12 June 2024

NSW Dep Planning, Housing and Infrastructure

REF: : APPLICATION NO. SSD-47105958
At : 24A KINGSCLIFF STREET, KINGSCLIFF, NSW 2487
Subject : PUBLIC SUBMISSION & DOCUMENTATION REVIEW COMMENTS

BUILDING SECTION R1

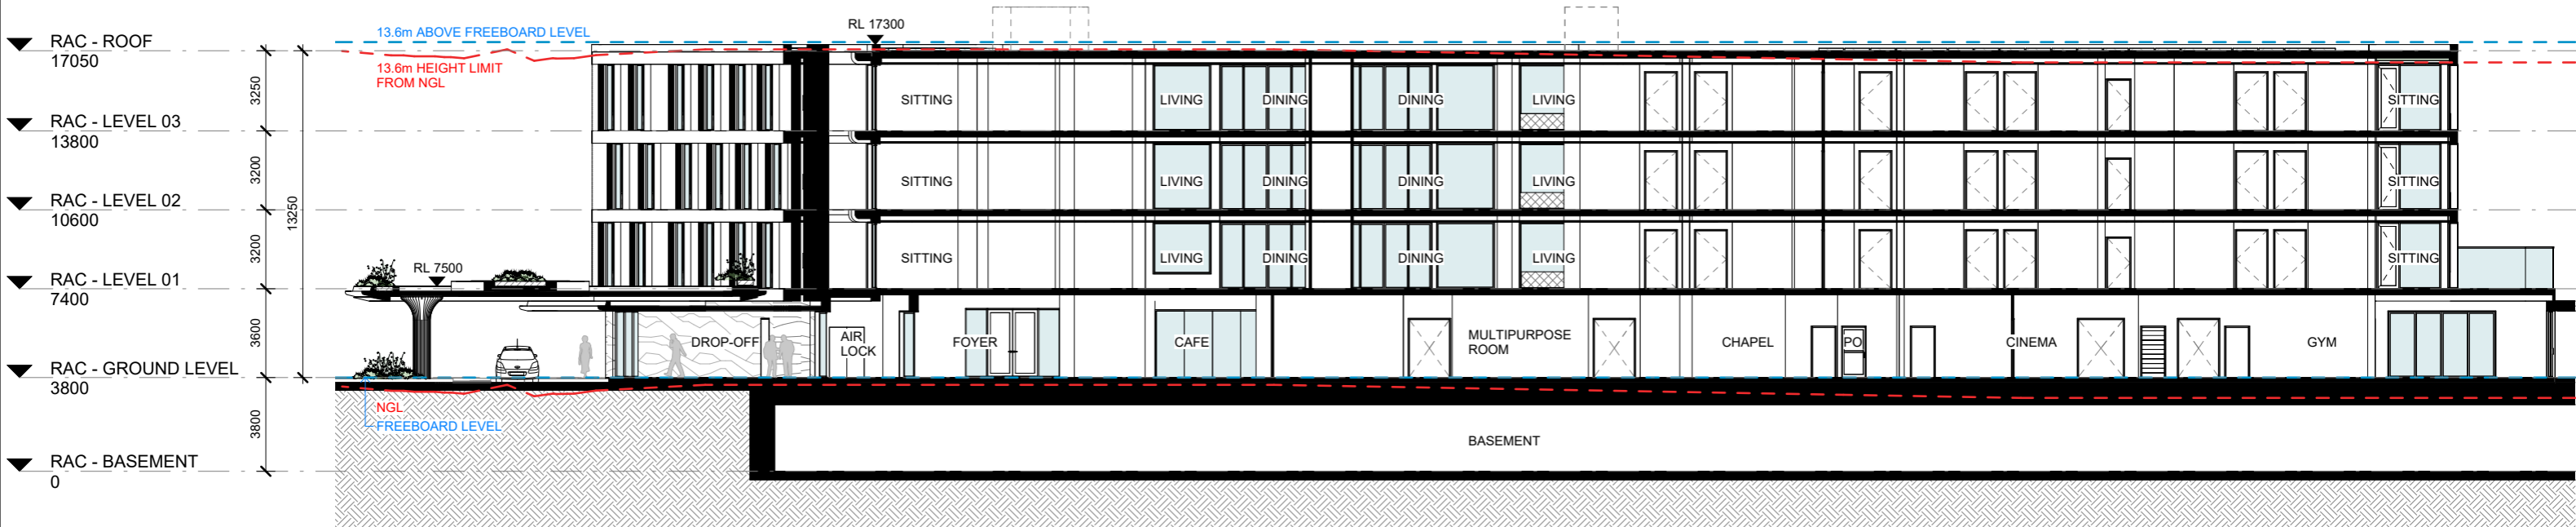
- The architectural documentation has incorrect RL's and natural ground lines shown on cross sections of the true lower height of ground lines to neighbouring build up land.

- Sections do not continue through to correctly demonstrate the height difference between the existing dwelling living spaces and the proposed ground levels.

- The architectural documentation does not show how the proposed fill and **all** areas of the development will interact with neighbouring property boundaries, such as cut/fill and retaining heights and how these are intended to be built or any adverse impacts on the properties in which they abut.
